CITY OF PORTLAND

Job ID: 2011-07-1749-SF

has permission to build a new Single Family Residence.

From: "Jonathan Rioux" <JRIOUX@portlandmaine.gov>
Date: August 22, 2011 1:46:39 PM EDT
To: <jonathan@redfernproperties.com>
Subject: RE: 23 Bay Street

**2 2ND FLOOR PLAN**  
1/4" = 1'-0"

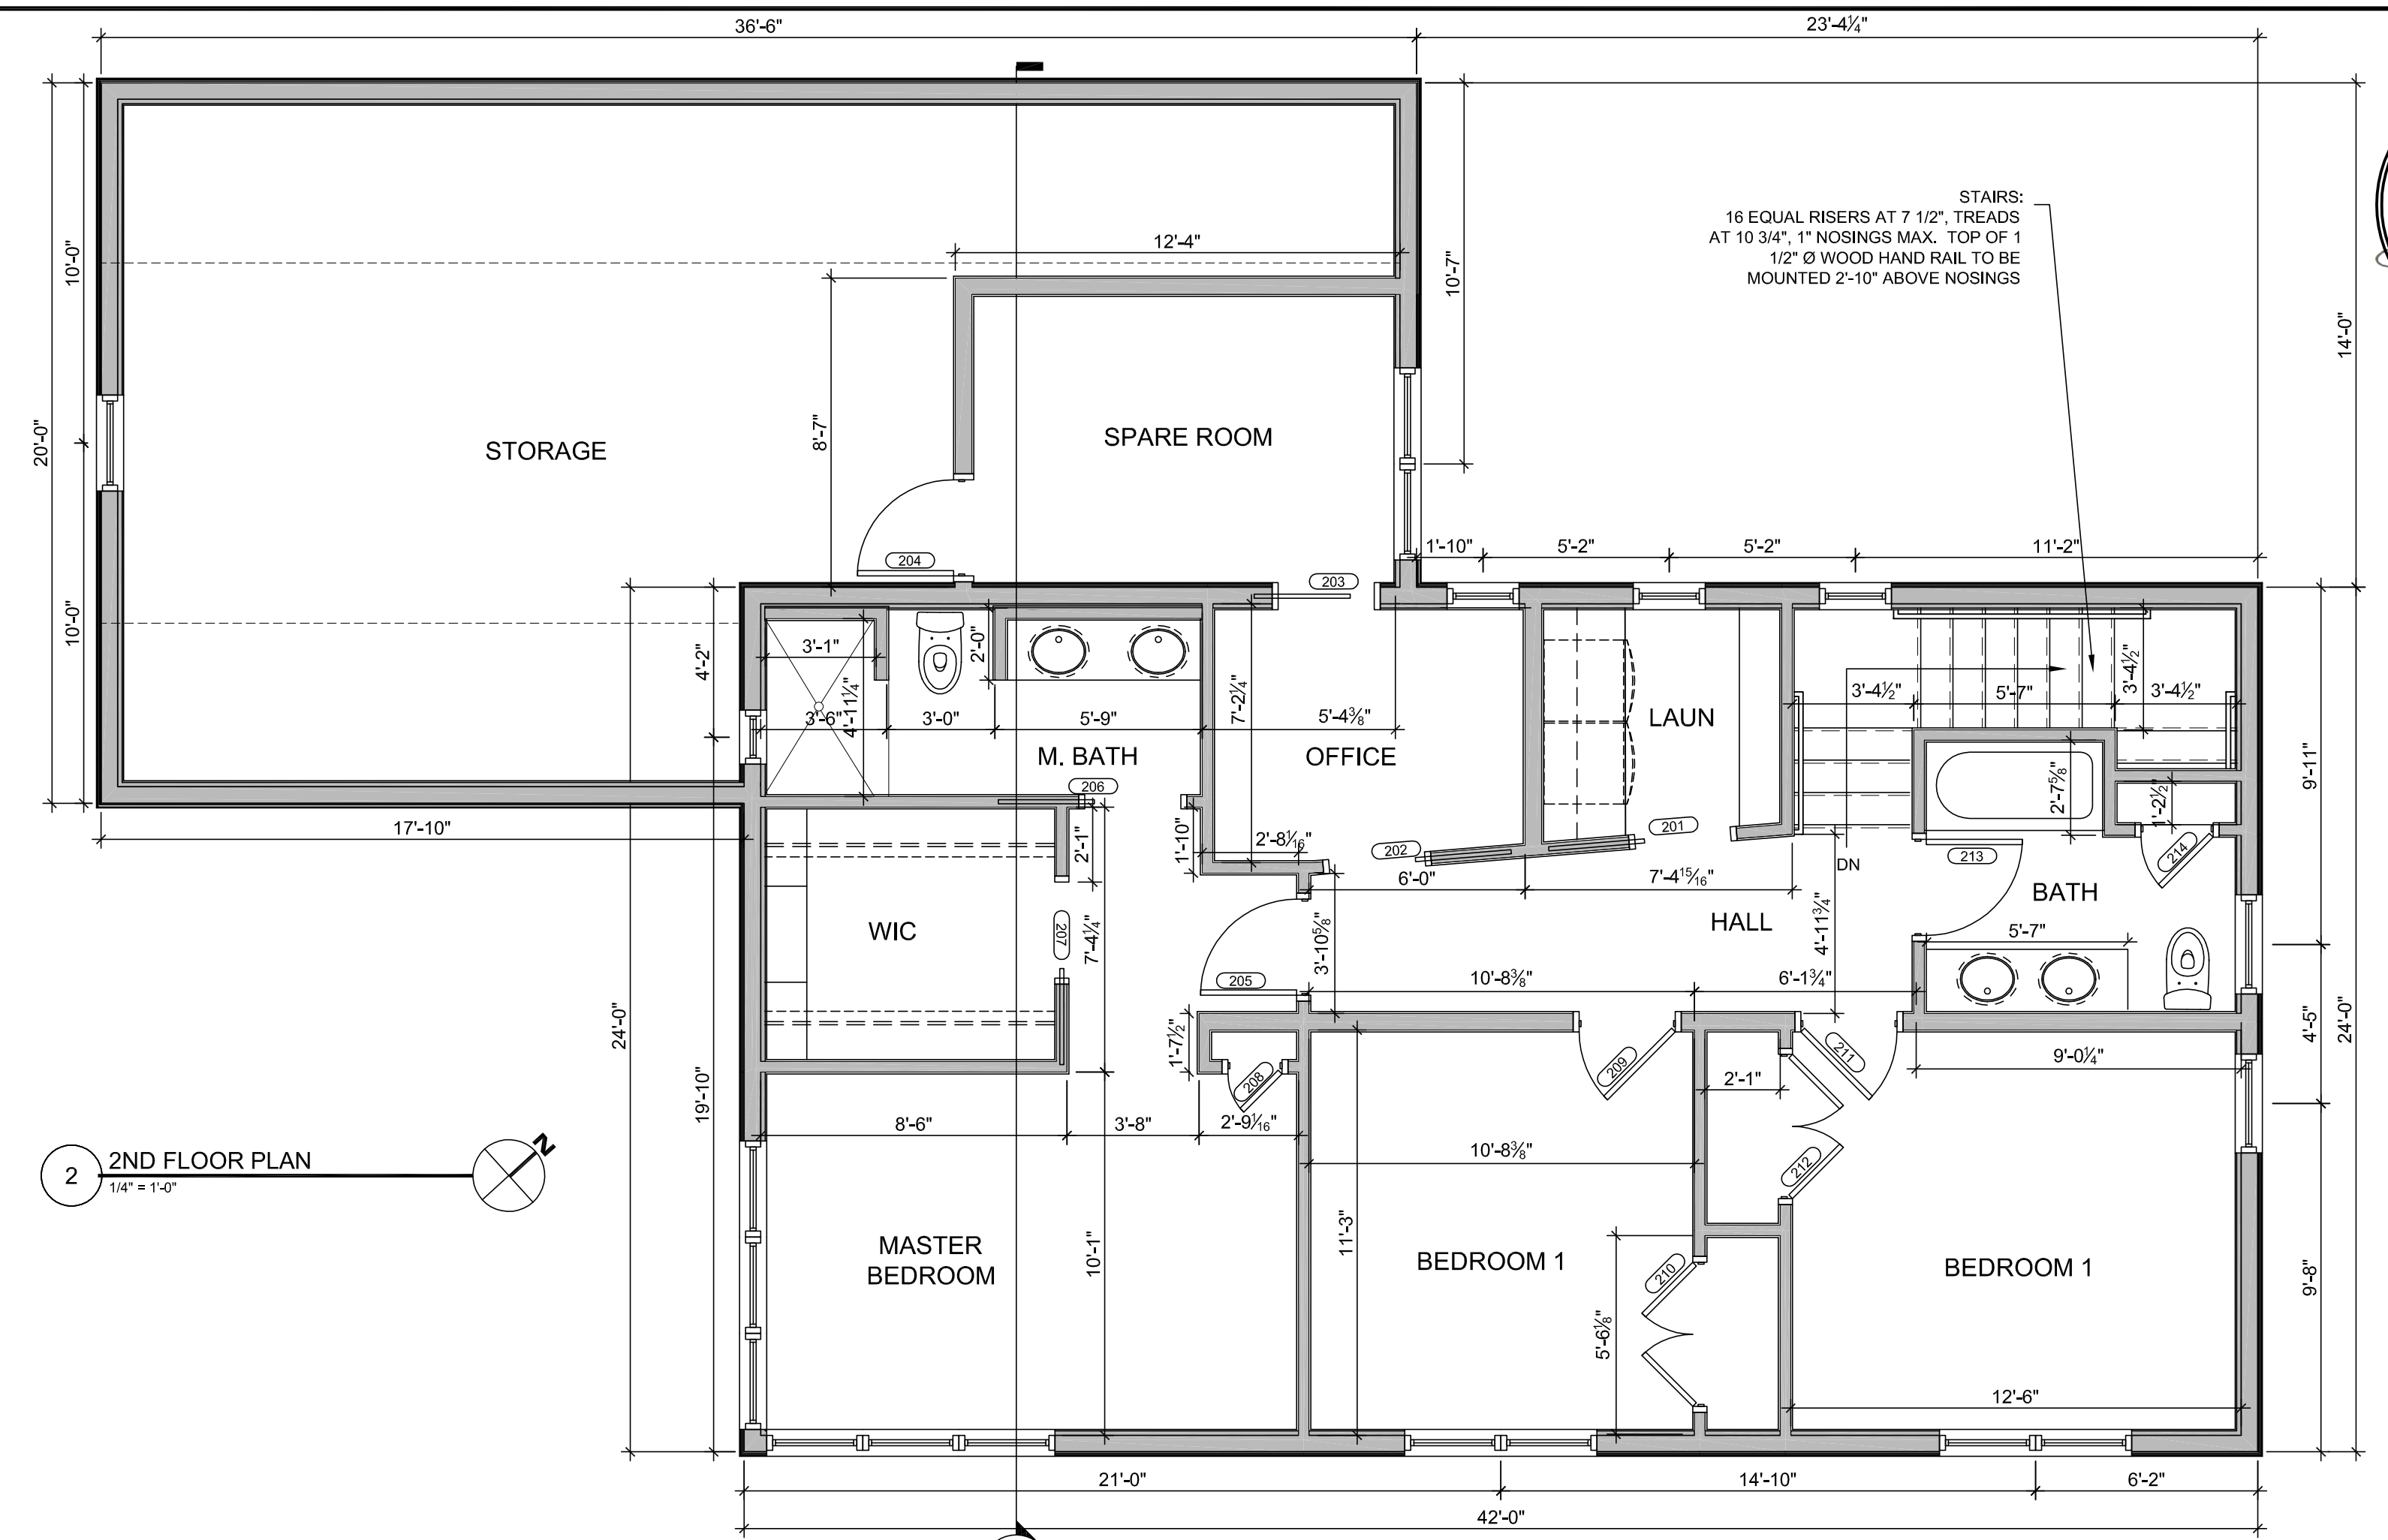
Windows:

- Window sills in locations more than 72 inches from finished grade shall be a minimum of 24 inches above the finished floor of the room, unless a window fall prevention devices is installed in accordance with section R612.3.
- A code compliant emergency escape shall be provided in the bedroom. Window sills in locations more than 72 inches from finished grade shall be a minimum of 24 inches (no higher than 44 inches) above the finished floor of the room.

We will be raising the 2nd floor windows by two inches to ensure their will be >24" above the finished floor. All bedrooms have windows that meet egress requirements.

**1 1ST FLOOR PLAN**  
1/4" = 1'-0"

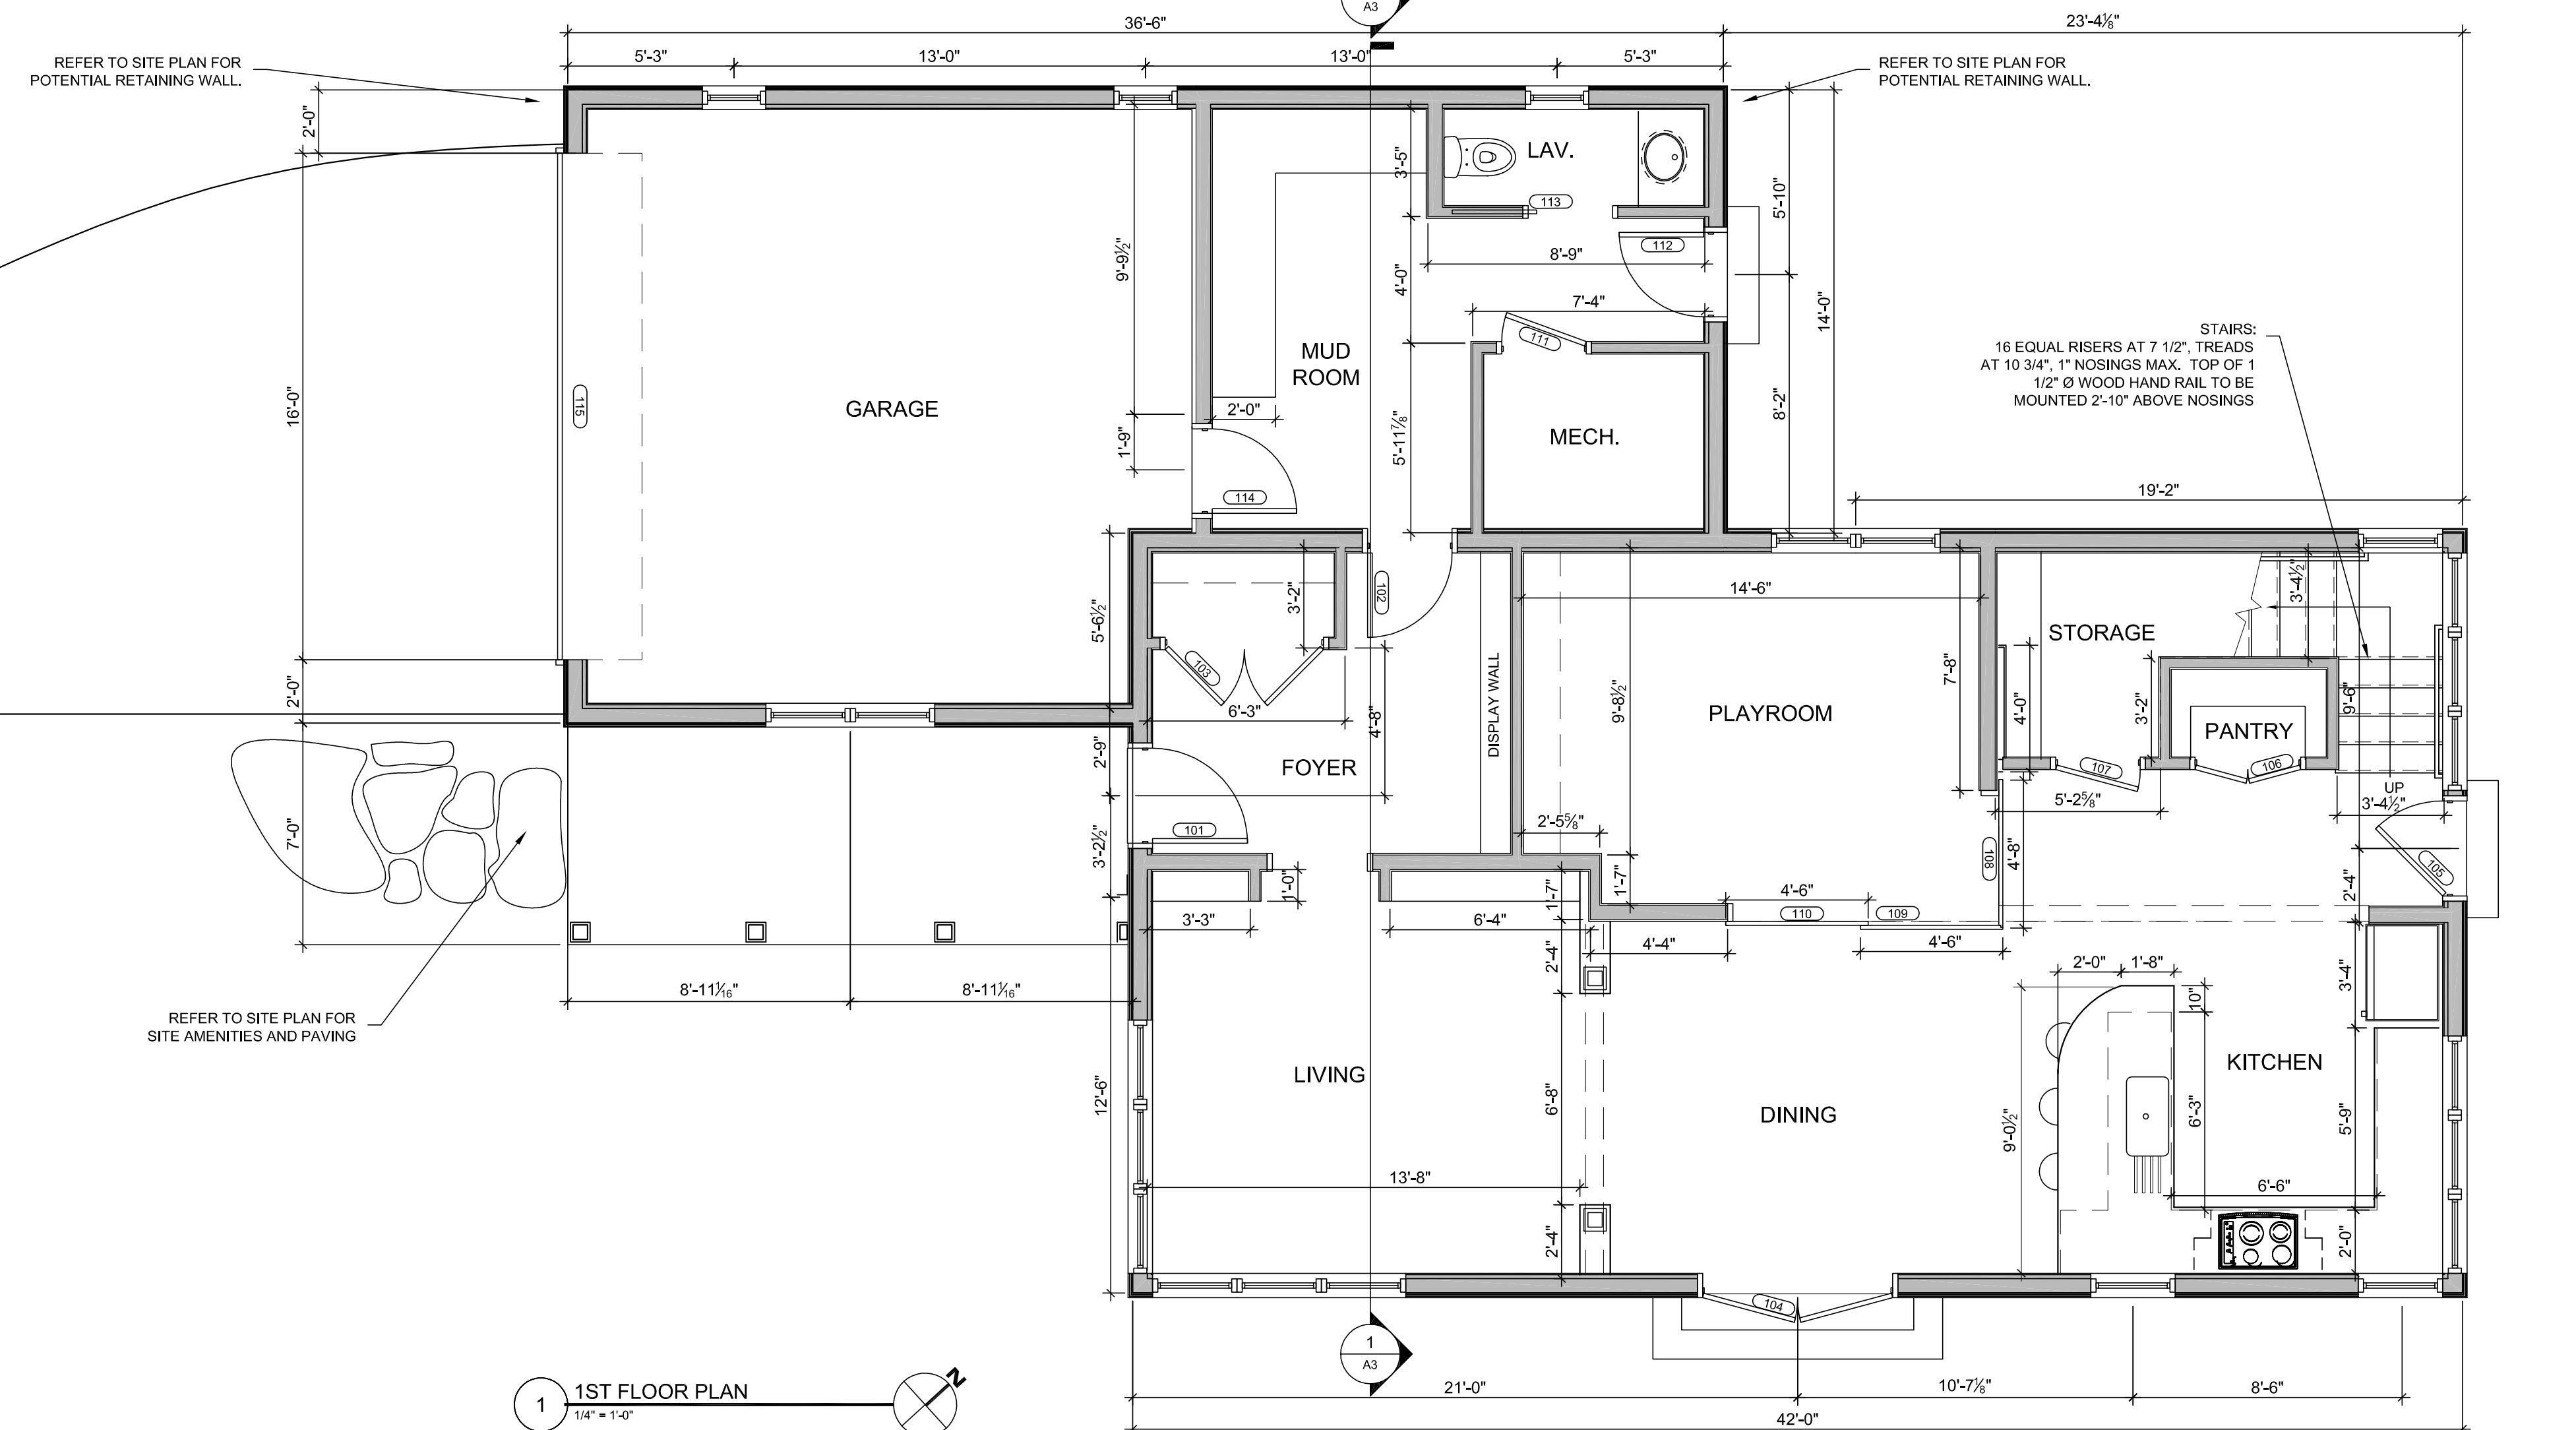
Number of Stairways

- Headroom (Section R311.5.2) Stairway headroom shall be not less than 6 feet 8 inches measured vertically from the sloped plane adjoining the tread nosing or from the floor surface of the landing or platform.

This is a single flight of stairs. The only place where this dimension comes close is at the beginning of the stairs under the linen closet, the bottom of which can be modified if necessary. The contractor shall verify a 6'-8" minimum clearance for the stairs. A scaled architectural sketch shall be issued prior to construction.

**A.3**

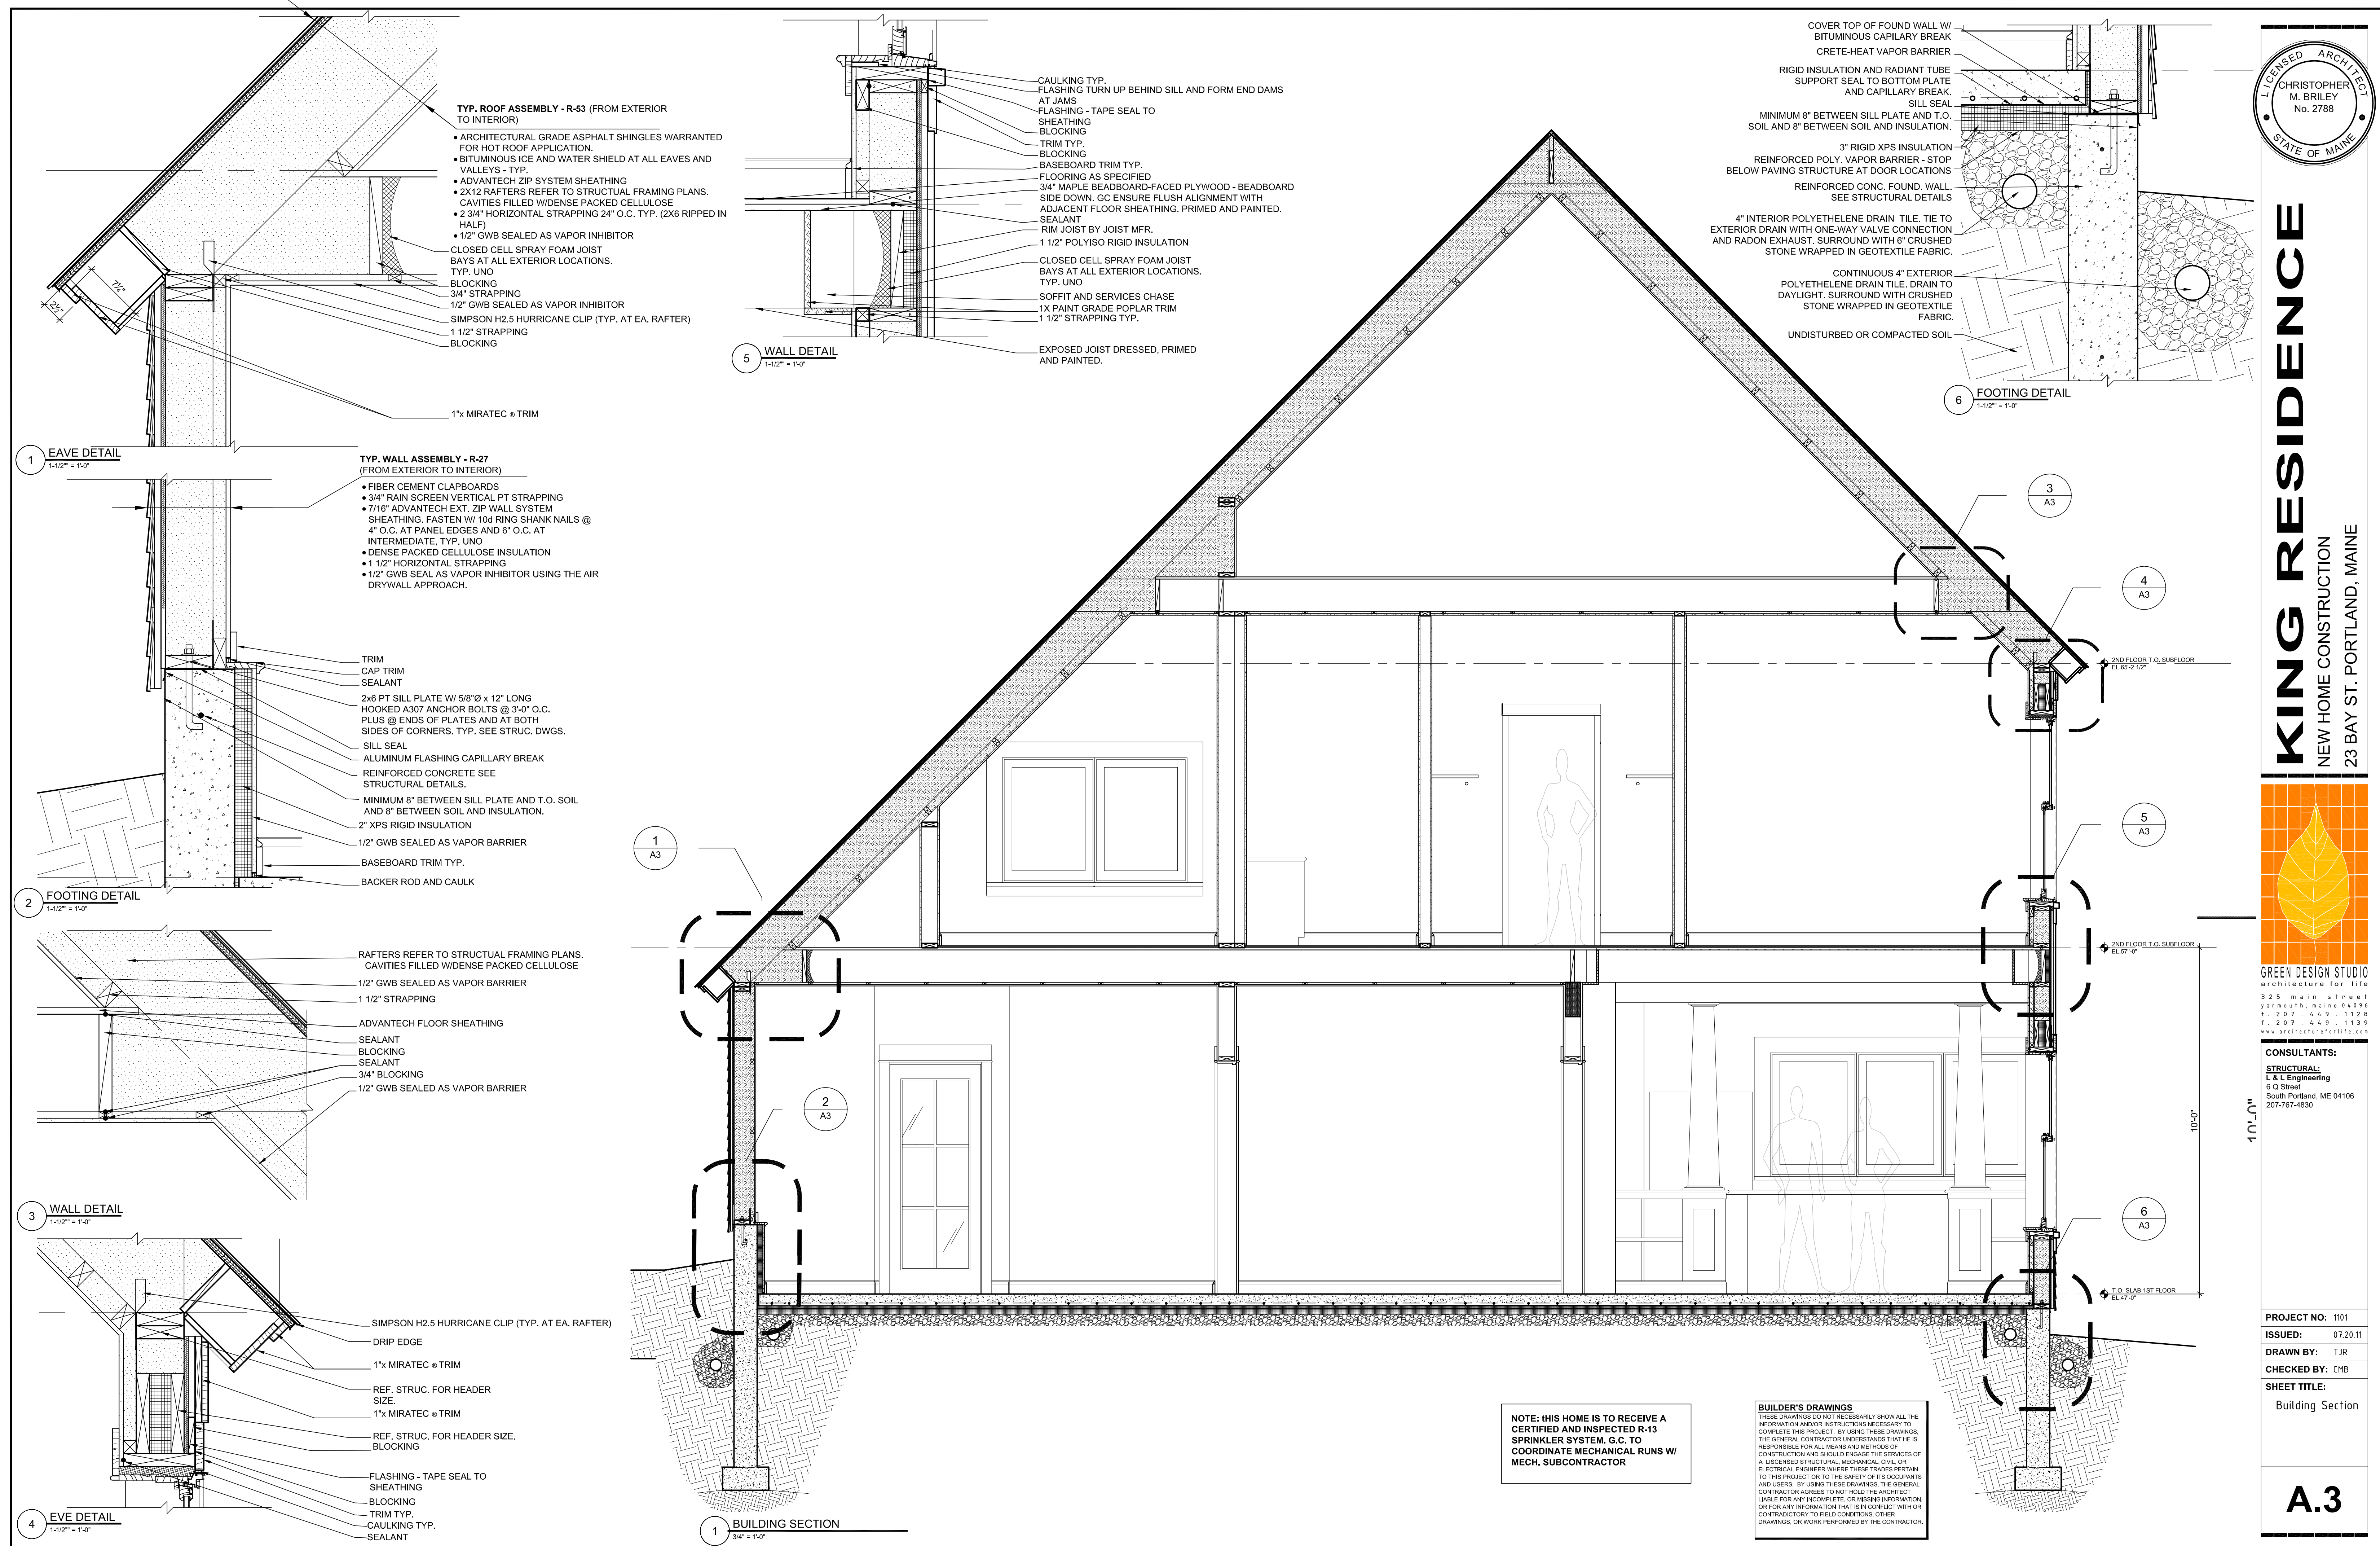
Building Envelope/ Energy Efficiency must comply with MUBEC

Typical R- values are as follows (and stated on the drawings, Sheet A.3). Rafters 53, Walls 27. The Slab has 3" of Rigid Extruded Polystyrene Insulation R=16.5. The Floor of the conditioned space over the garage has an R-value of 45.6
